Addendum No. 1

RE: Contract ID C203096

Beaufort County

NC-99 From SR-1722 To The End Of Pantego Creek Bridge

SUMMARY OF QUANTITIES

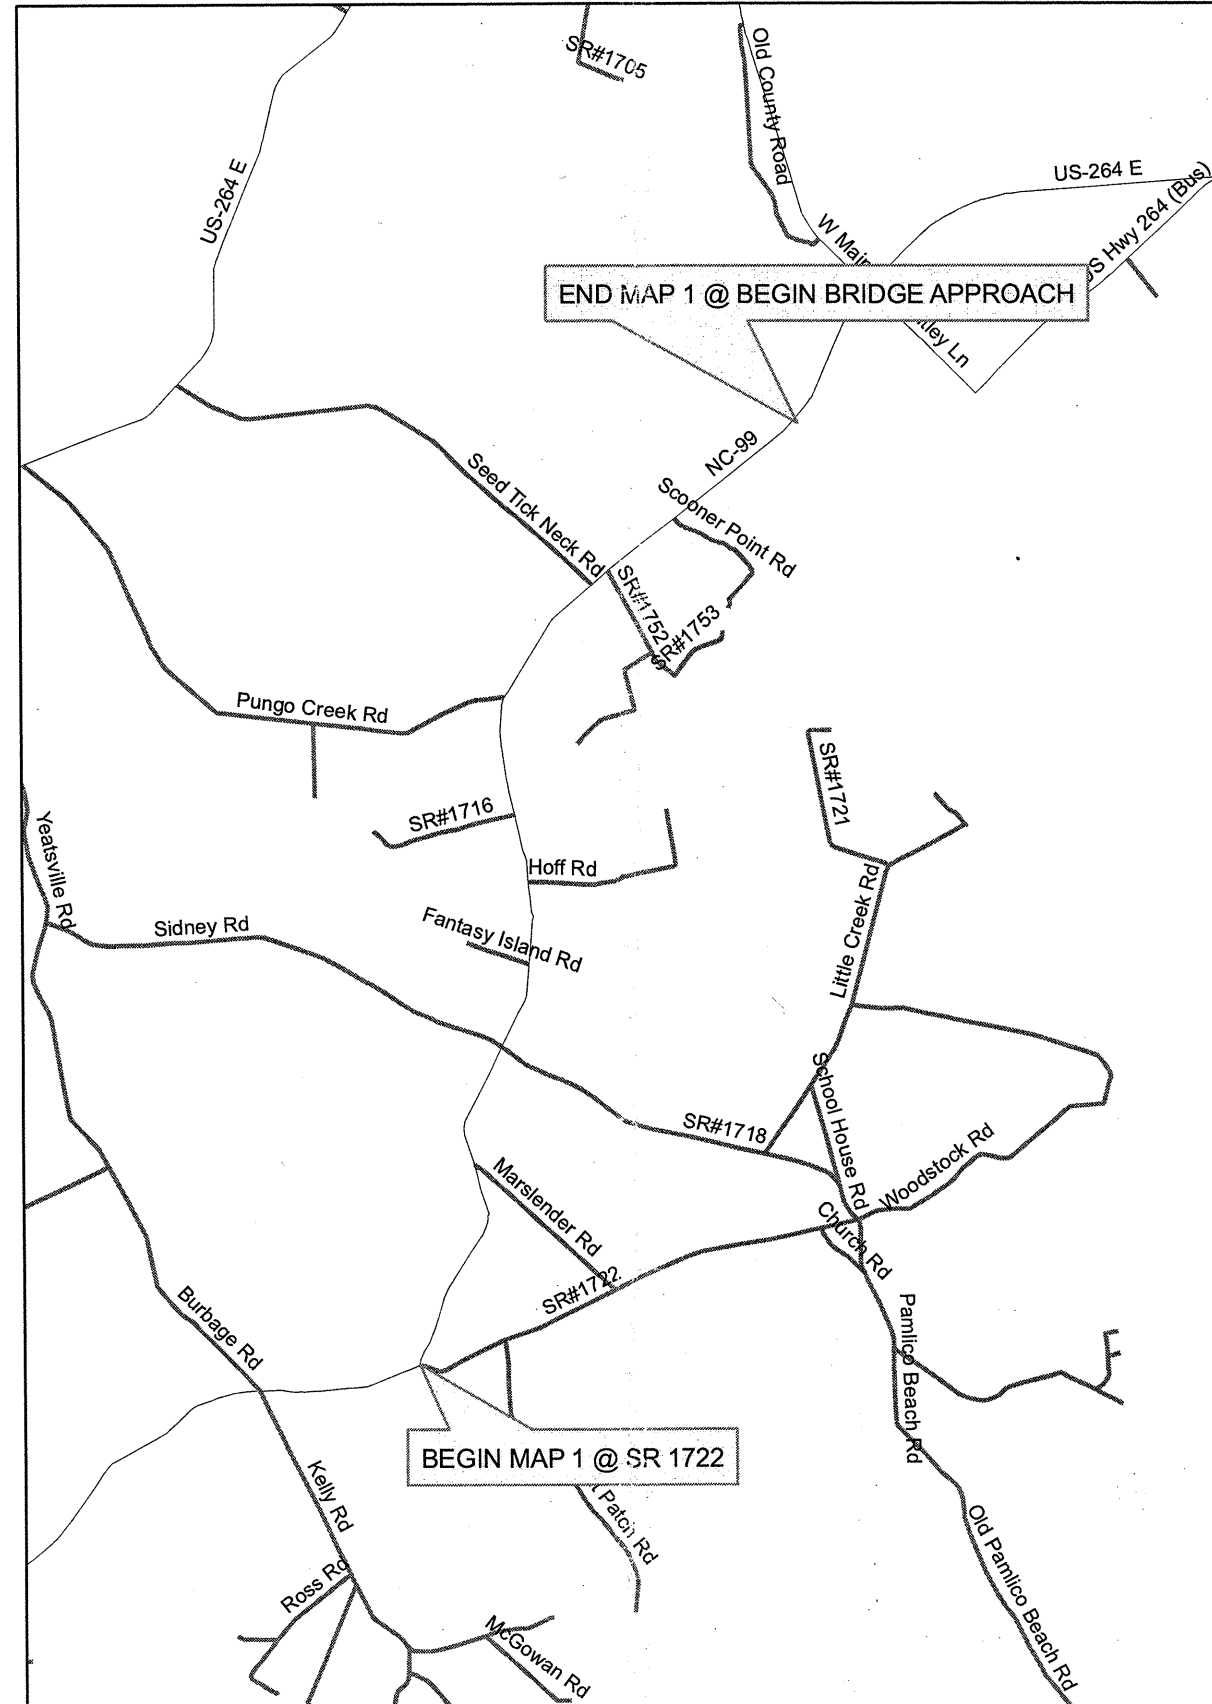
On Sheet No. 3 the below noted quantity changes have been made to the "Summary of Quantities". Please void Sheet No. 3 in your plans and staple the revised Sheet No. 3 thereto.

<u>Item</u>	<u>Description</u>	<u>Old Quantity</u>	<u>New Quantity</u>
2-0106000000-E-230	Borrow Excavation	273 CY	DELETED
3-1220000000-E-545	Incidental Stone Base	6,835 Ton	2,728 Ton
22-0255000000-E-SP	Aggregate Shoulder Borrow	NEW ITEM	4,640 Ton
